Appeal Decision

Appeal Ref: APP/R5510/D/24/3351070

131 Waltham Avenue, Hayes, UB3 1TE

- The appeal is made under section 78 of the Town and Country Planning Act 1990 (as amended) against a refusal to grant planning permission.
- The appeal is made by Mr Nigel Withey against the decision of the London Borough of Hillingdon.
- The application Ref is 38802/APP/2024/1517.
- The development proposed is ground floor extension to existing extension.

SITE: 131 Waltham Avenue Hayes Middx	
TITLE: PROPOSED GRD FLR EXT'N PROPOSED PLANS AND ELEVATIONS	
Drawn SH	Checked
Date DEC'16	Scale 1:50 & 1:100
Drawing No. <u>K / 1016 / WA2</u> Revision <u>  </u>

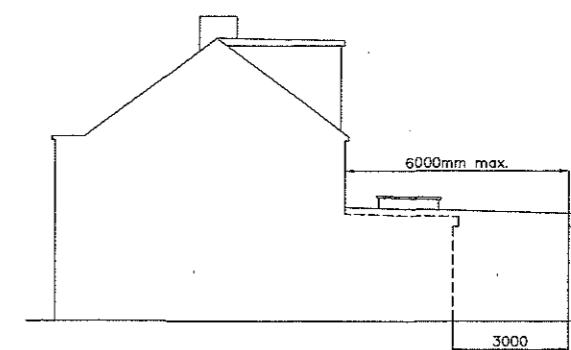
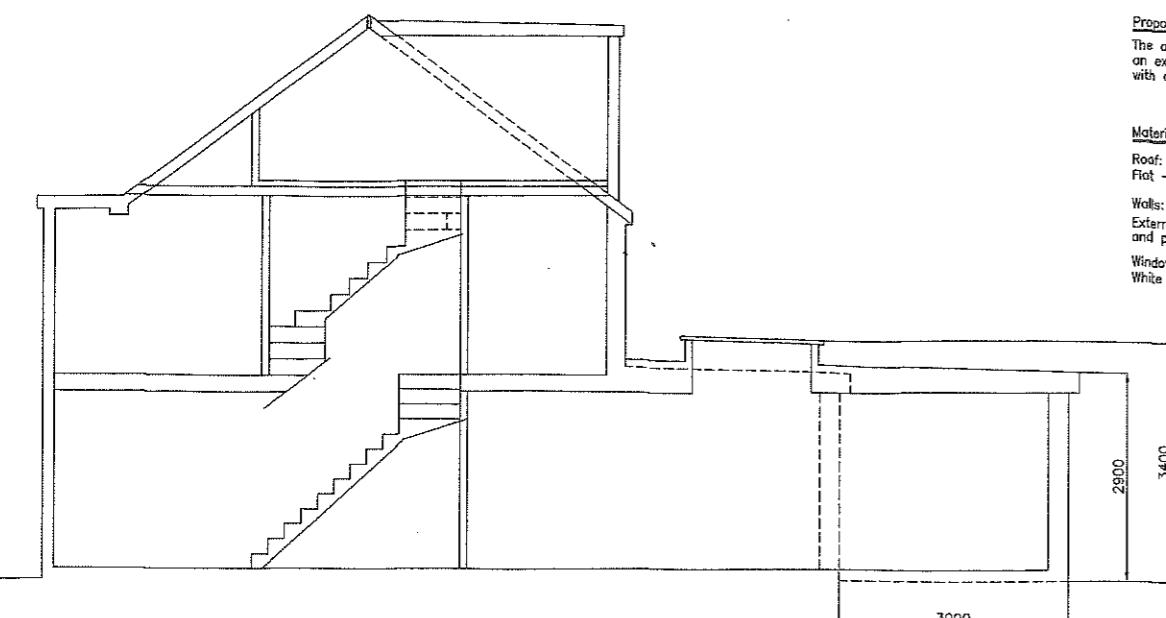
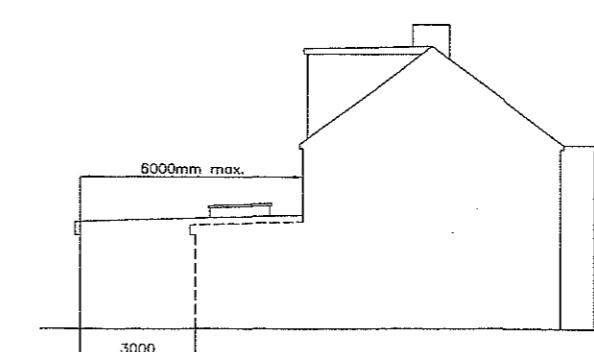
including loss of light and outlook. The garden areas to the appeal site and neighbours are long and have an open southerly outlook, some with extensions and therefore with differing degrees of enclosing built form along shared boundaries. The proposal would introduce built form along the boundaries with both neighbours. However, whilst the adjoining dwelling on its western side (No.133) is already enlarged to a greater extent than the existing situation at No.131 such that the proposal would be of no effect to those occupiers, what is proposed would introduce an additional 3m of single-storey built form along the shared boundary on its eastern side.

6. However, Policy DMHB11 of the LBH DMP also given as RFR requires high standard of design and that development 'should not adversely impact' upon the amenity, daylight and sunlight of adjacent properties. The circumstances of each case will differ and in that regard the open outlook and southerly orientation are material in this matter and several of the neighbouring dwellings have large rear extensions. Although the proposal would extend a single-storey height enclosure to a depth of 6m from its rear elevation I note that No.129 has more than one seemingly temporary structures already within its garden and close to the rear habitable room windows which limit outlook and access to daylight. Taking all factors into account, I consider that the impact of what is proposed would not be unacceptable due to the extent of outlook and southerly orientation available to occupiers of No.129 and, consequently, there would be no conflict with the relevant policy that I have outlined above or with the development plan taken as a whole.

1. The appeal is allowed and planning permission is granted for Ground floor extension to existing extension at 131 Waltham Avenue, Hayes, UB3 1TE in accordance with the terms of the application, Ref 38802/APP/2024/1517, and the plans submitted with it, subject to the following conditions:
 - 1) The development hereby permitted shall begin not later than 3 years from the date of this decision.
 - 2) The development shall be carried out in accordance with the following approved plan: K/1016/WA2.
 - 3) Materials used in the construction of external surfaces of the development hereby approved shall match in appearance those found in 131 Waltham Avenue, the host dwelling.
